Transport
Roads & Traffic
Authority

**MIXED USE RESIDENTIAL, RETAIL AND COMMERCIAL DEVELOPMENT
330 CHURCH STREET, PARRAMATTA**

20 September 2011

01 PLAN - PARKING LEVEL 01
1:200 @ A1

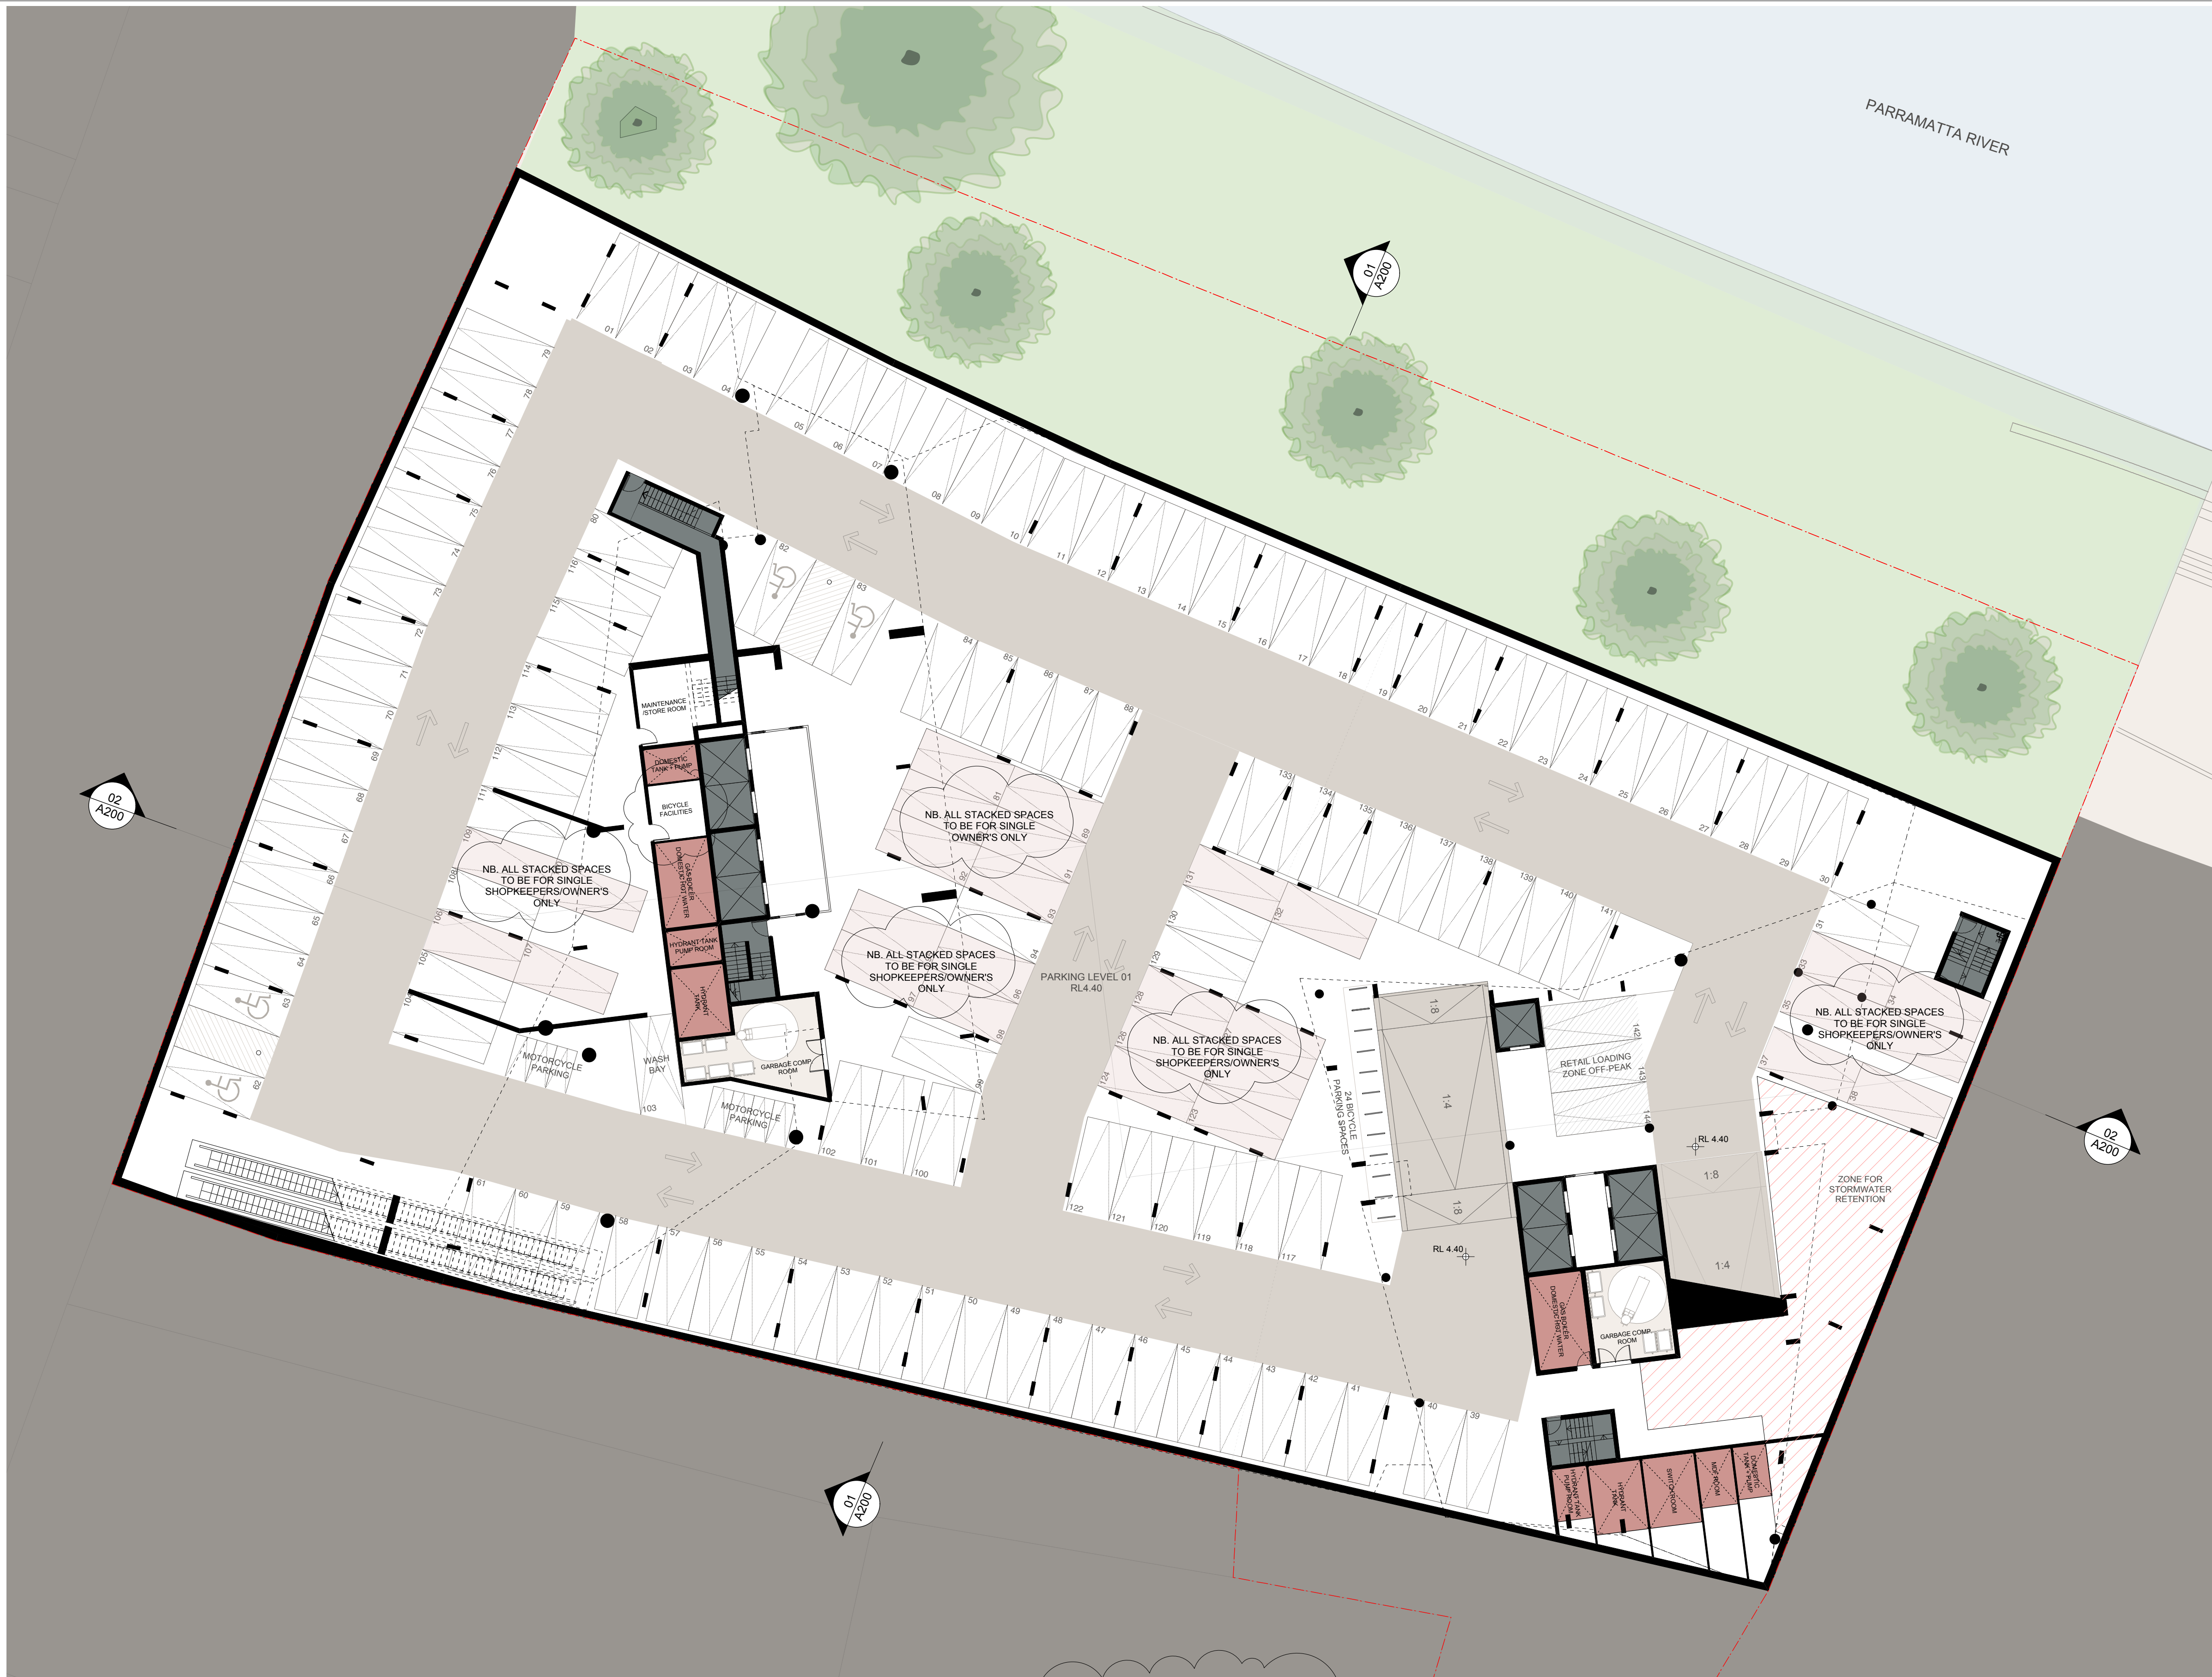
2. It is noted that one car parking space per unit is proposed as part of the development and a number of parking spaces within the basement carpark are stacked. It is not practicable to use stacked parking spaces when only one space per unit is allocated. It is suggested that stacked car parking spaces are removed. The RTA will support providing less number of parking spaces at this location to encourage the use of sustainable transport.

3. No bicycle parking spaces are provided as part of this development. It is recommended adequate and convenient bicycle parking facilities are provided within the development.

PROJECT
RIVERFRONT APARTMENTS
330 CHURCH STREET
PARRAMATTA NSW
DRAWING NAME
Plan_Level 00 Retail

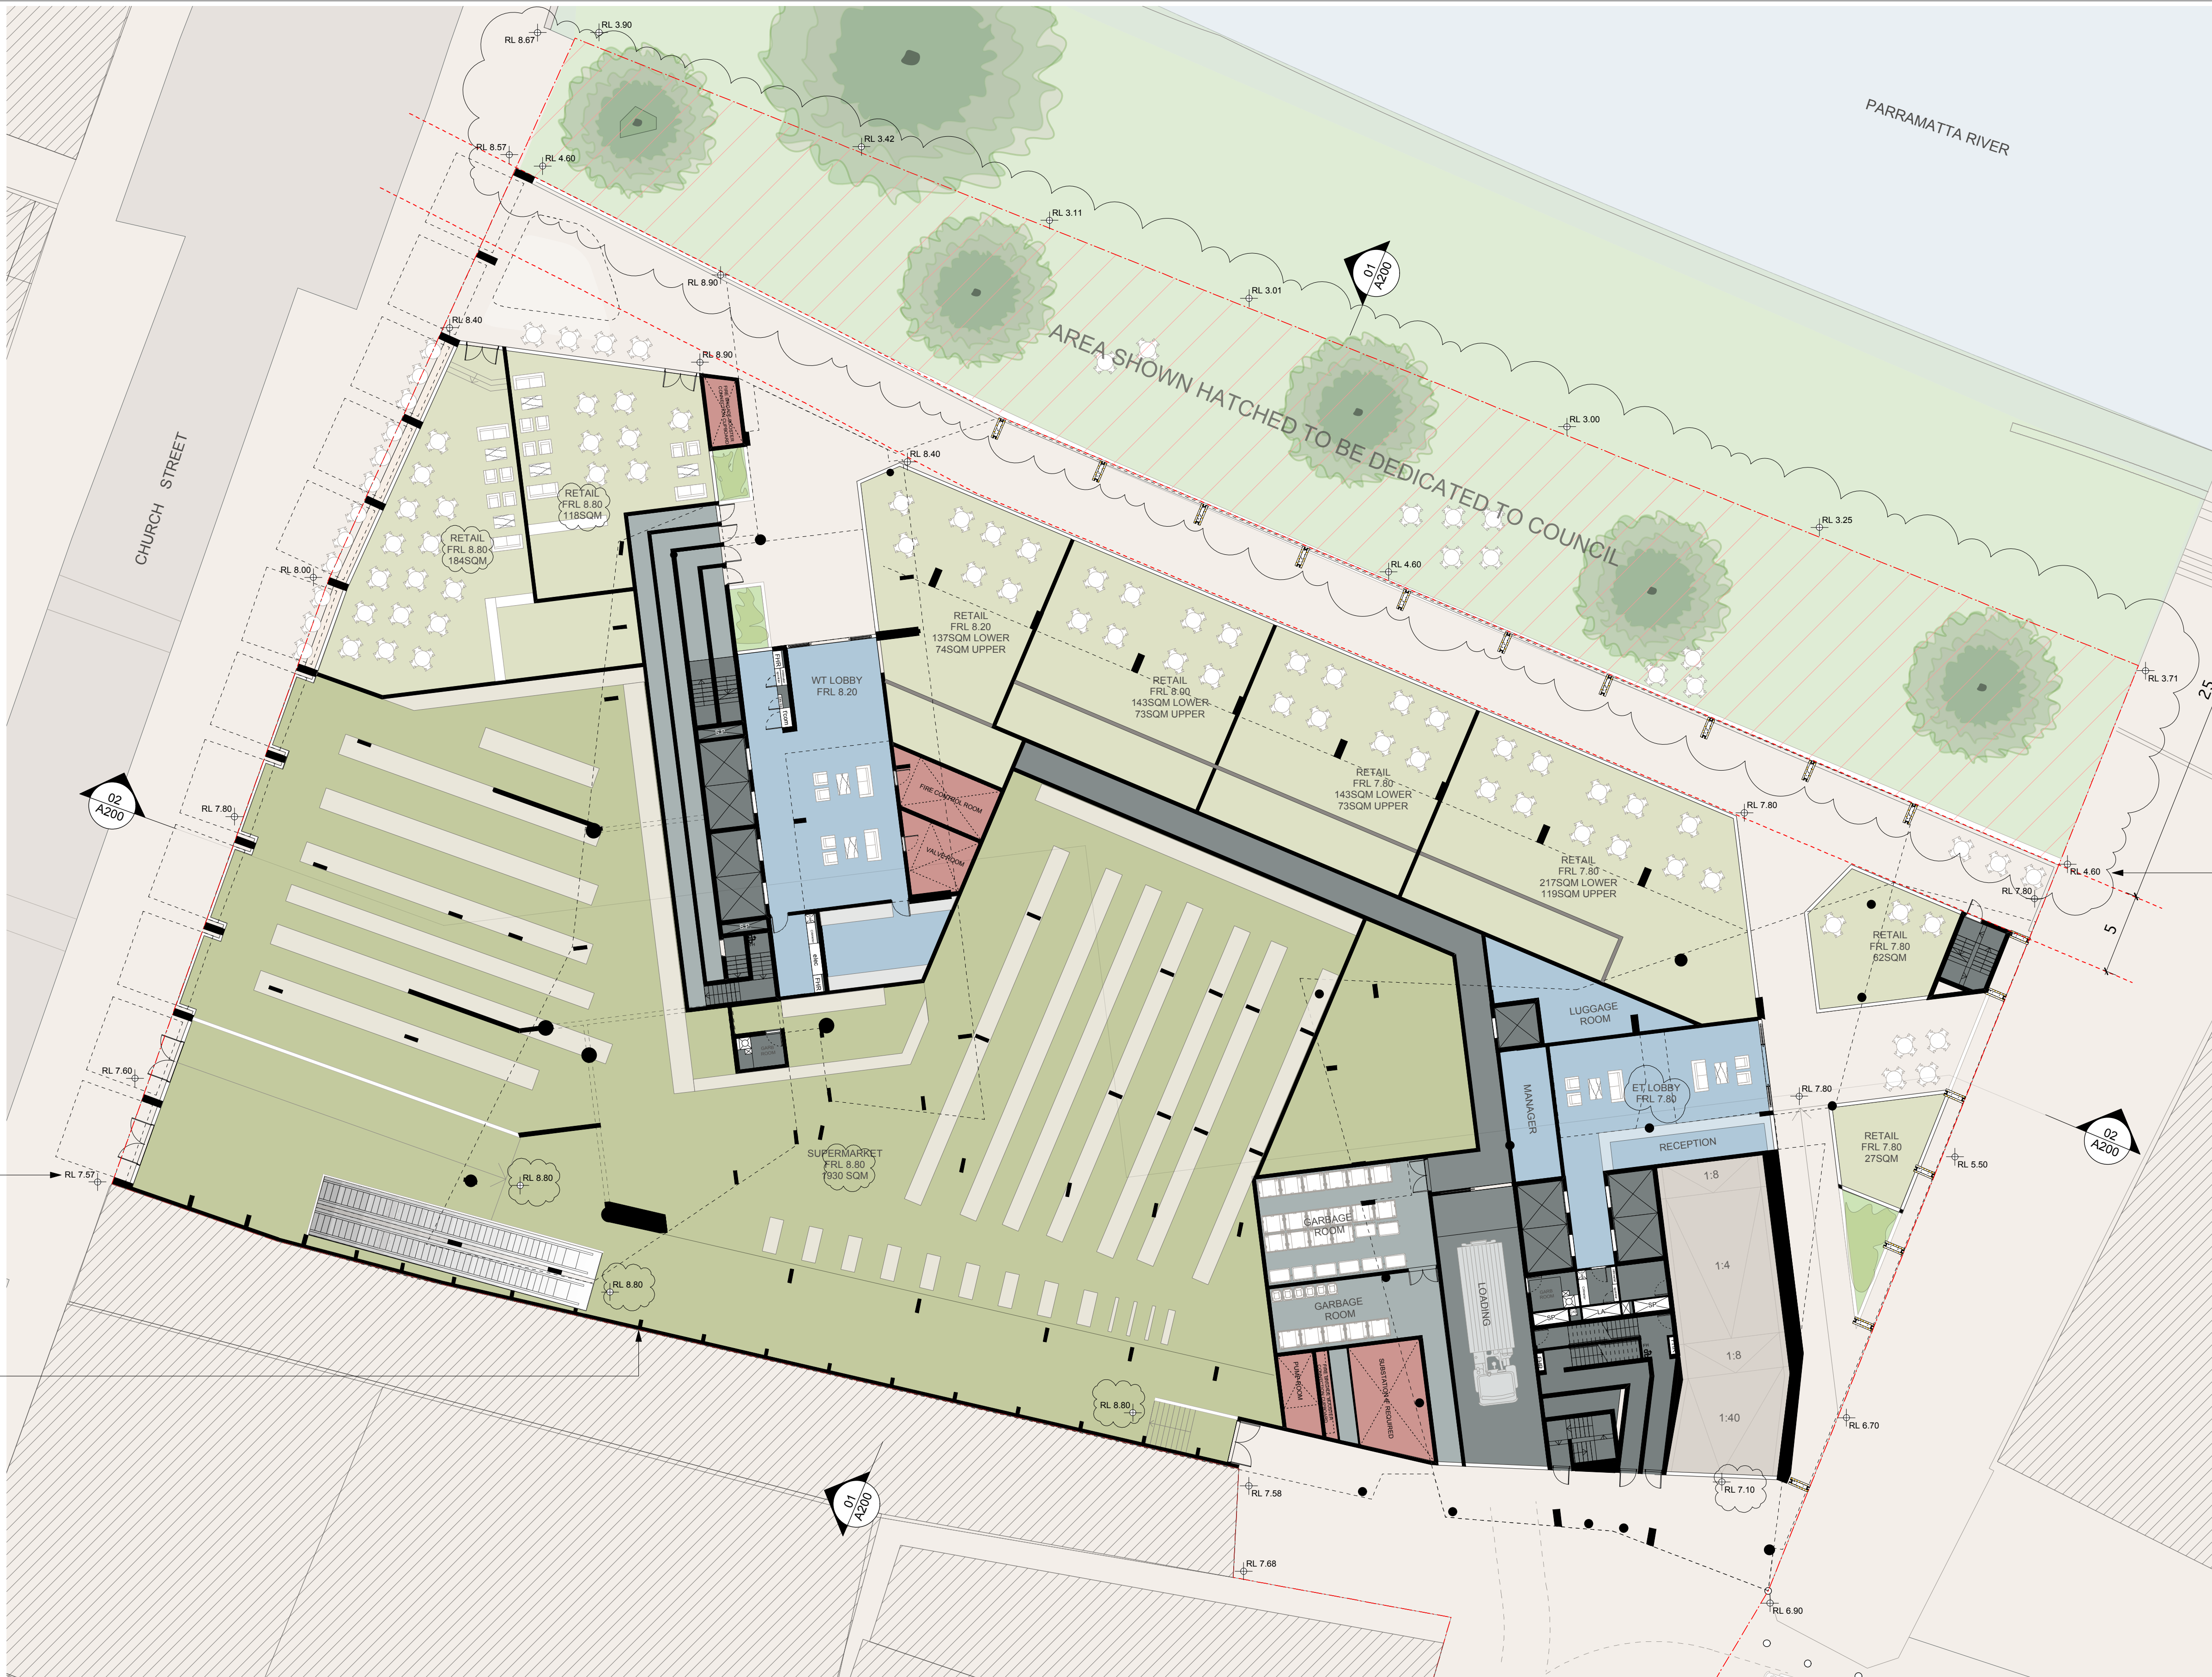
1. The proposed single loading dock facility for Heavy Rigid Vehicle (HRV) is inadequate to service the proposed development. It is recommended that a minimum of two loading docks, to accommodate HRV vehicles, are provided as part of this development.
